Oifig na
nOibreacha Poiblí
Office of Public Works

O.P.W Ref No. 227-2026

Re: Case Number: ACP-323900-25, Proposed upgrades to Limerick Wastewater Treatment Plant and Regional Bioresource Centre, Bunlicky, County Limerick.

FIGURE 3-2: CORCANREE PS PROPOSED SITE LAYOUT

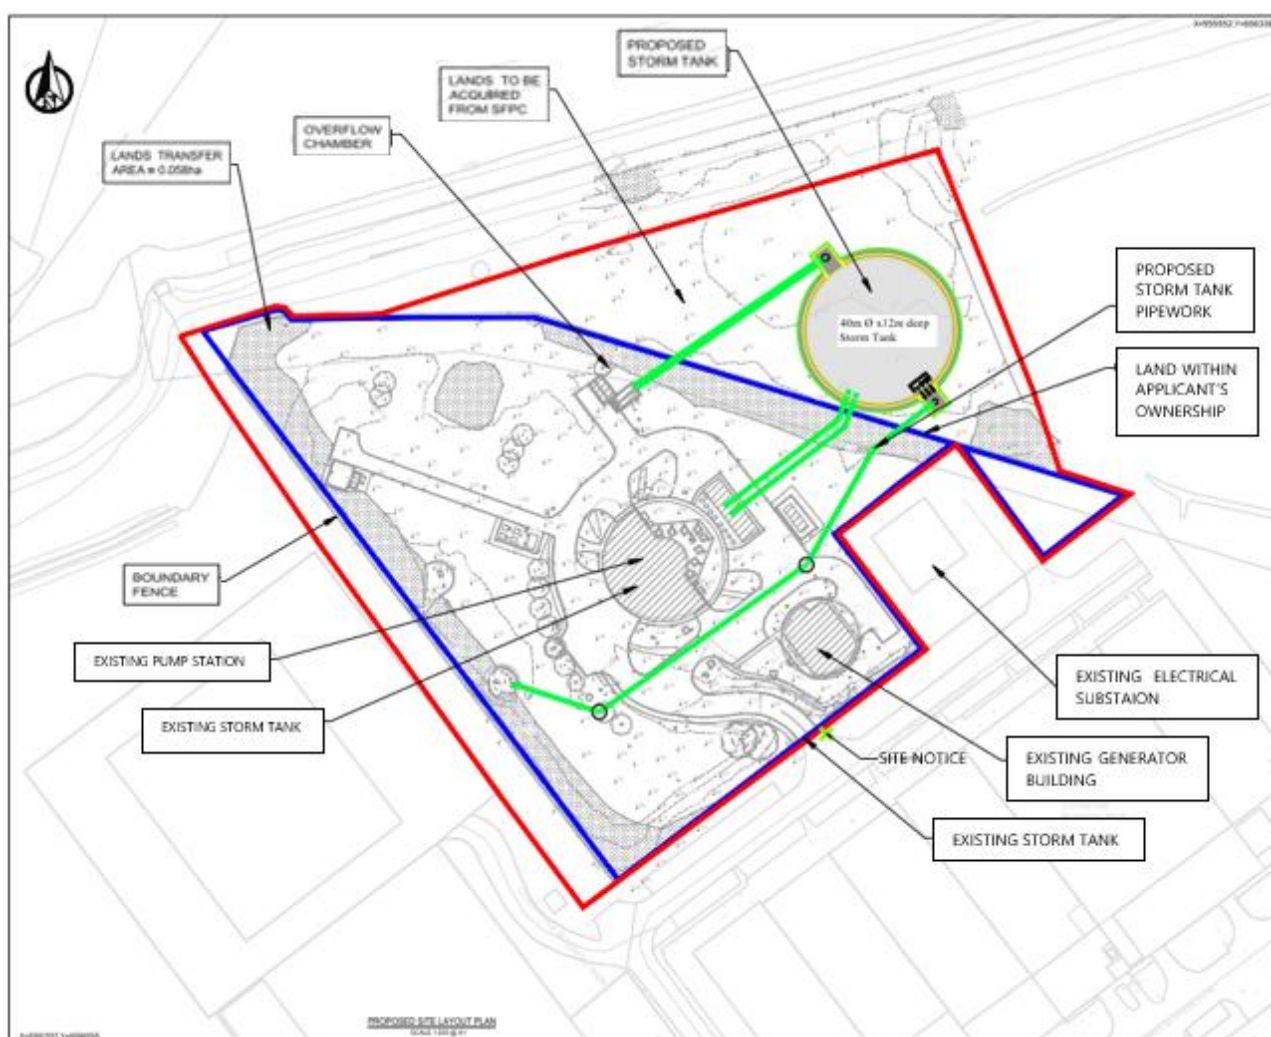
The site on Map A which contains Corcanree Pumping station is bounded on the Northern side by OPW Channel D1 of the Polefield Arterial Drainage Scheme which is under the auspices of this office. In order to gain access for the purpose of maintaining this channel, the Office of Public Works requests that the following be included as a Condition of any Grant of Planning Permission.

This office would request that a 5 Metres Wide strip be retained, adjacent to the channel D1 to facilitate on-going access and maintenance requirements. This strip should be unimpeded to mechanical plant and should not be landscaped, paved or otherwise developed in a manner that would impede or prevent access to said channel.
